Application No: FP/183/20/HH
Site Address: 8 South Road Felpham PO22 8EF
Description of works: Rear and side single storey extension with balcony and guarding above the rear portion.

Thank you for your internet representation made on 8th October 2020 which has been recorded as an objection with the comments as follows:

PROPOSED FIRST FLOOR PLAN

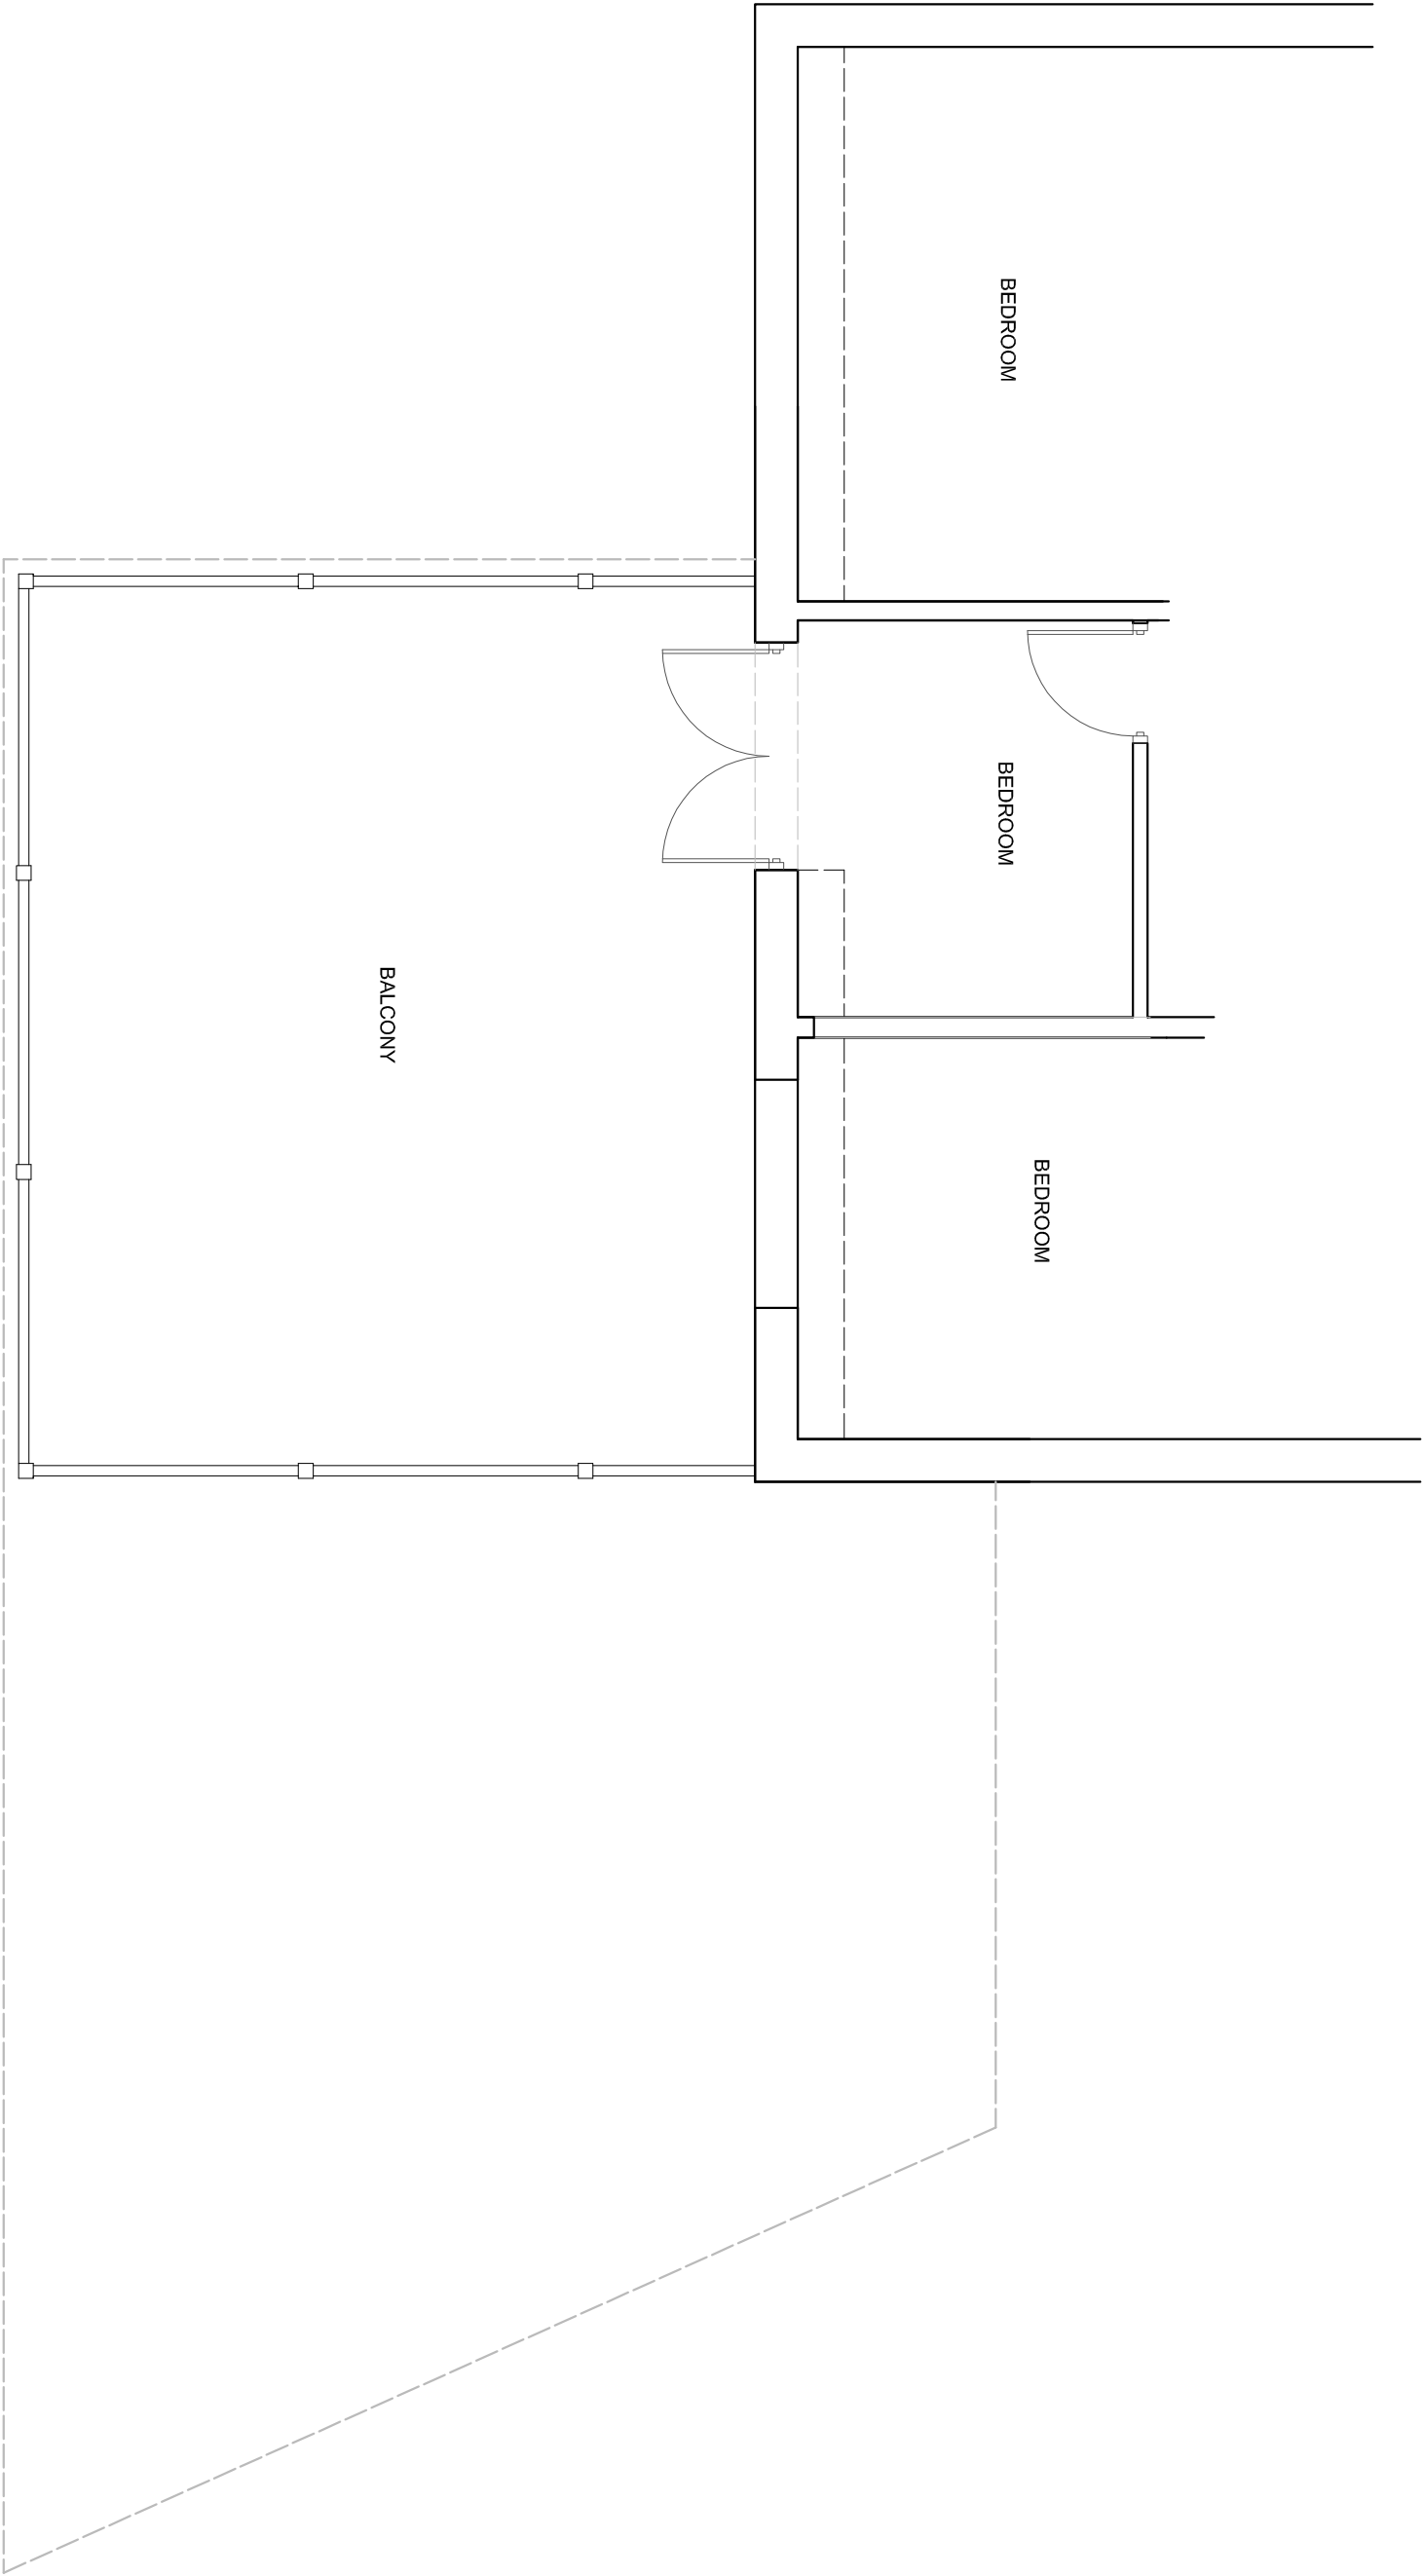
Furthermore, from the plans presented there the proposed balcony at the rear of no. 8. The size of the proposed balcony (ie the overall length), will overlook 9 and 10 South Road rear gardens.

Hence I am writing to object to the current size of balcony proposal at no. 8 South Road on the grounds of "Nuisance by interference with a neighbour's quiet enjoyment of his or her land " namely No. 9 and 10 South Road.
